# TIERRA WEST, LLC

September 26, 2024

Responses to Comments on Retail at 7 Bar Conceptual Grading Plan and Conceptual Drainage Report. Hydrology File: B14D010D

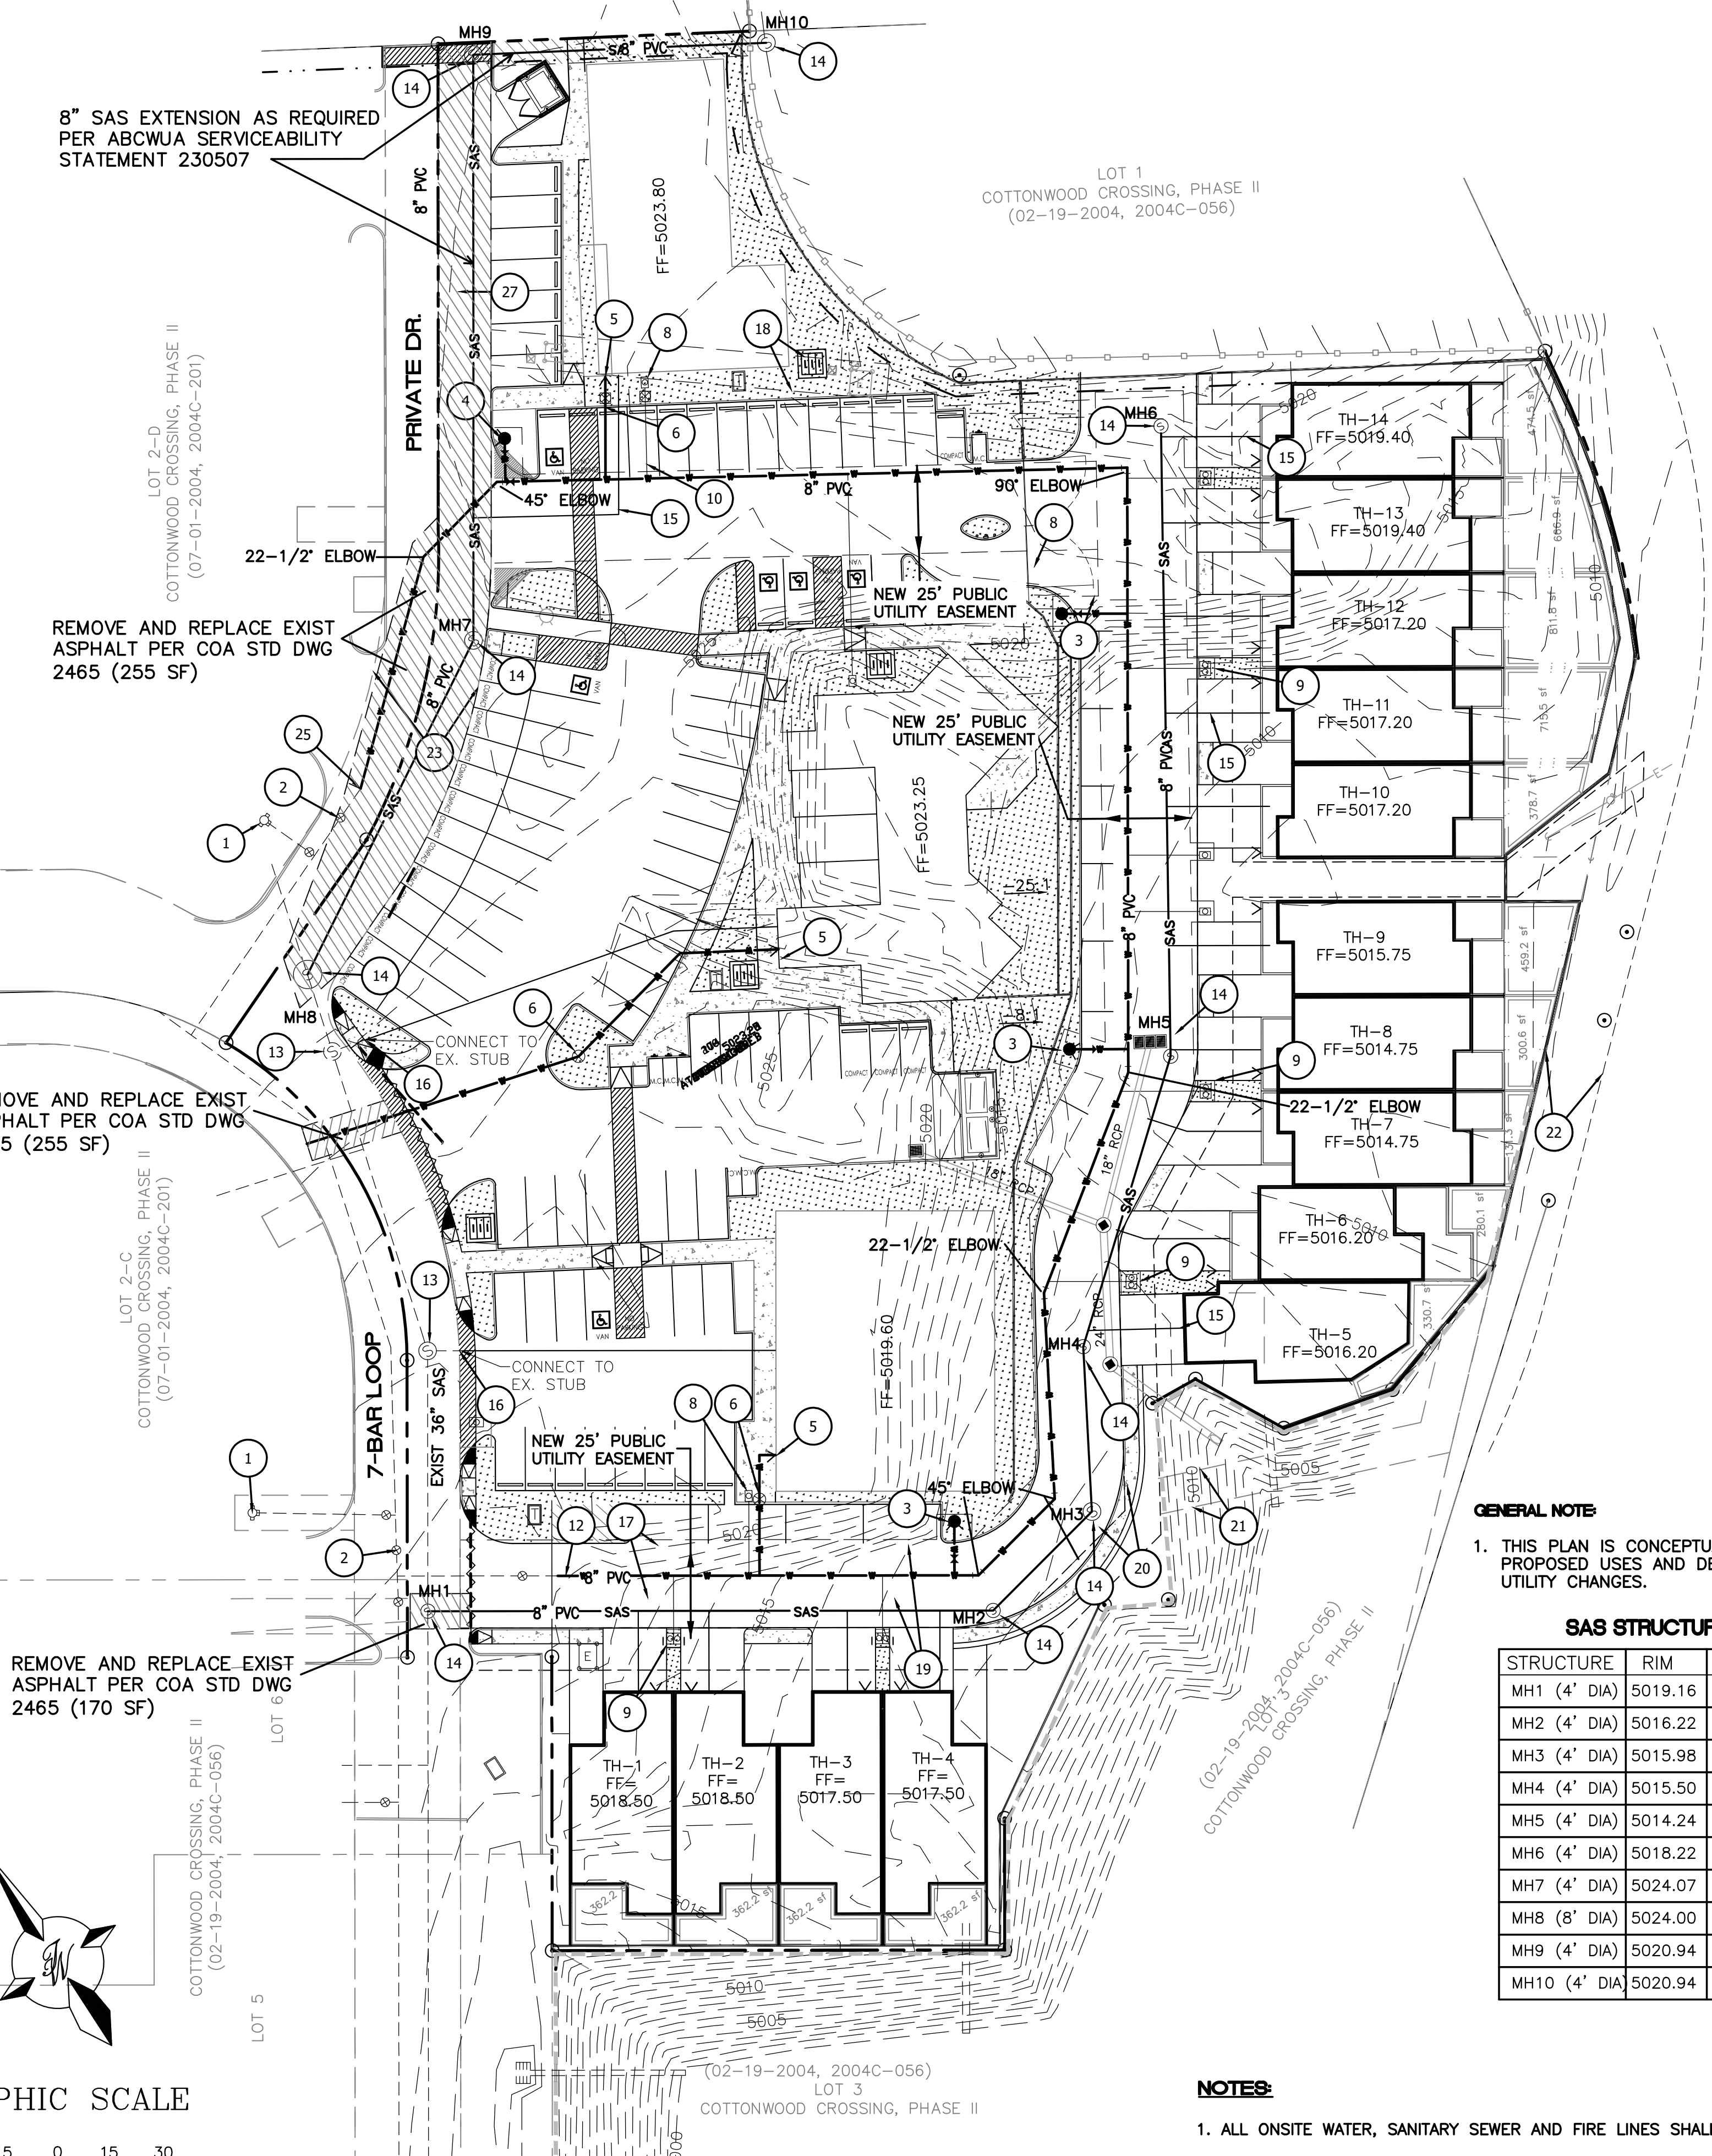
3. Townhomes 1-4 show walls extending to the back existing wall, are wall extensions to be provided for Townhomes 5-14? This may affect the ponding behind Townhomes 5-14.

4. The earthen fill materials proposed for the small retention basins at the backs of the Townhomes should be considered and identified to confirm application of intended uses.

5. Please show Cross Lot Drainage Easements if needed on the Grading & Drainage Plan specifying the beneficiary and a maintenance agreement.

6. The spot elevations shown at the middle entrance to the development appear to conflict with the delineated drainage basin boundaries in the Conceptual Drainage Report.

7. The spot elevations shown at the southern area of Building B appear to conflict with the delineated drainage basin boundaries in the Conceptual Drainage Report.

- 1. Response – The layer showing the property walls that separate the Townhomes backyards for townhomes 5-14 were not shown on the previous**

***submitted drawing. This has been corrected and the walls are now shown and reflect the configuration shown in Townhomes 1-4***

1. ***Response – Under “Construction Notes” the following note was added.***

- a. ***Note #8 - All fill material utilized within the Town Home detention pond area(s) must be suitable for drainage and percolation. The fill shall consist of clean, well-graded granular material, free from clay, silt, organics, or other deleterious substances that may impede drainage. No clay or expansive materials are to be used in the fill to ensure proper infiltration and prevent standing water.***

1. ***Response – A New “General Note” was added as follows;***

- a. ***A drainage easement will be granted on Tract X (HOA) for the benefit of Tracts X through X (Townhomes 1-14), Tract X (Building B), and Tract X (Nusenda Bank). The HOA will be responsible for maintenance of this easement. The easement will be formalized through platting action prior to construction, at which time legal tract names will be added to the construction drawings.***

1. ***Response – Revised and added additional spot elevations to show the functioning water block as intended. Removed Demo layer items that area as well for clarity.***

1. ***Response – Basin Boundary was updated to address the conflict***

- ***Weighted E Table was updated to reflect the updated SF's of the revised basin.***
- ***Conceptual G&D Plan was updated with revised applicable flows as a result of basin changes.***
